## City of Albuquerque Stormwater Construction Site Inspection Report

ESC File No.	N09E014	Project Name:	Desert Sands		
NPDES Id. No.	NMR1000BE	Location:	3000 98th St SW		
1/27/2021	Owner	Contractor			
Operator	LGI Homes				
Contact name & title	Eddie Loven				
e-mail	<a href="mailto:Eloven@lgihomes.com">Eloven@lgihomes.com</a>				
Contact Phone #	872-1700				
COA Inspector	Doug Hughes	Start/End Time:	4:30pm		
Construction Phase:	infrastructure complete				
Type of Inspection:	<input checked="" type="checkbox"/> Regular	<input type="checkbox"/> Storm Event	<input type="checkbox"/> Post Storm Event >0.25"	<input type="checkbox"/> 311/Complaint	<input type="checkbox"/> Follow Up
Weather at time of inspection?	Clear	Temperature:	~	70	
Estimated date of last storm 0.25" or greater	2/22/2021

Erosion Sediment Control Plan

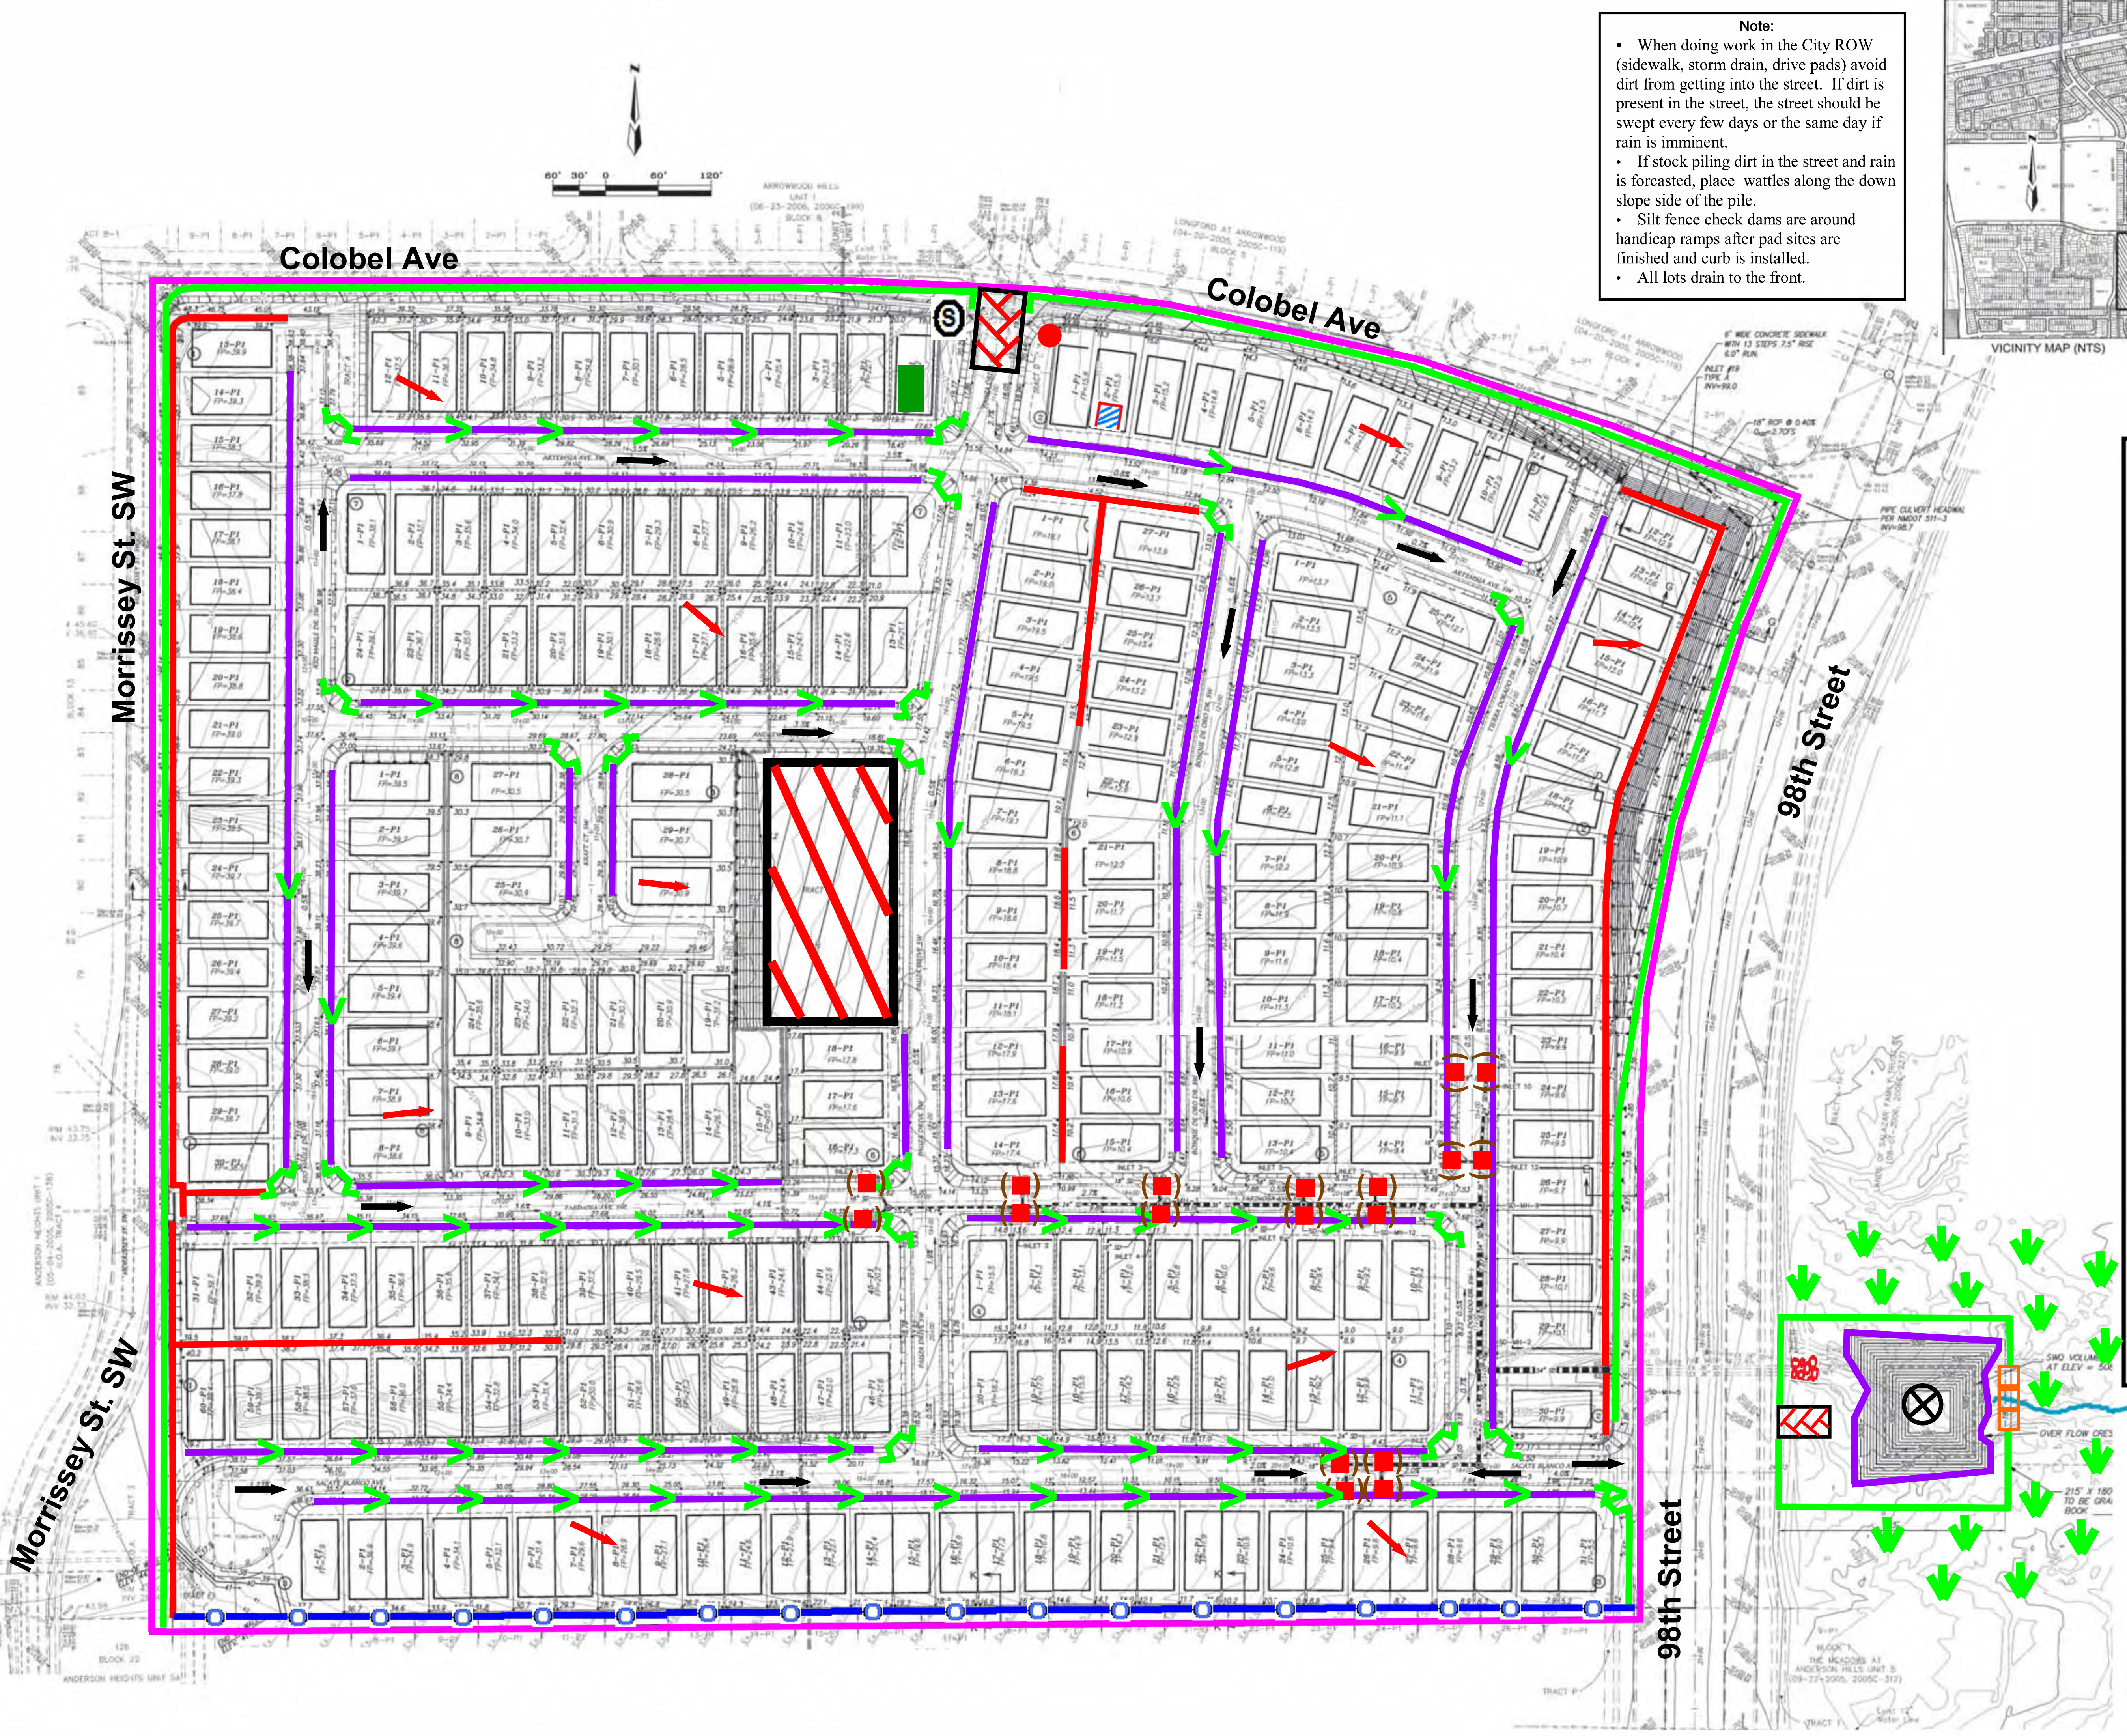
Item Number	Deficiency/ Corrective Action				
1	The NPDES coverage needs posted near the north pond. The SWPPP location must also be identified on the sign.				
2	Stabelization of the offsite pond failed. It needs to be weeded, and stabelized with seed and mulch per CGP 2.2.14.b..				
3	Self inspection is required every 2 weeks until the final stabilization criteria (CGP 2.2.14.b) is satisfied. Please provide the latest report.				
4	Silt fence is missing. Please construct silt fence as barrier to protect seed unless stabilized immediately with seed and gravel mulch.				
5
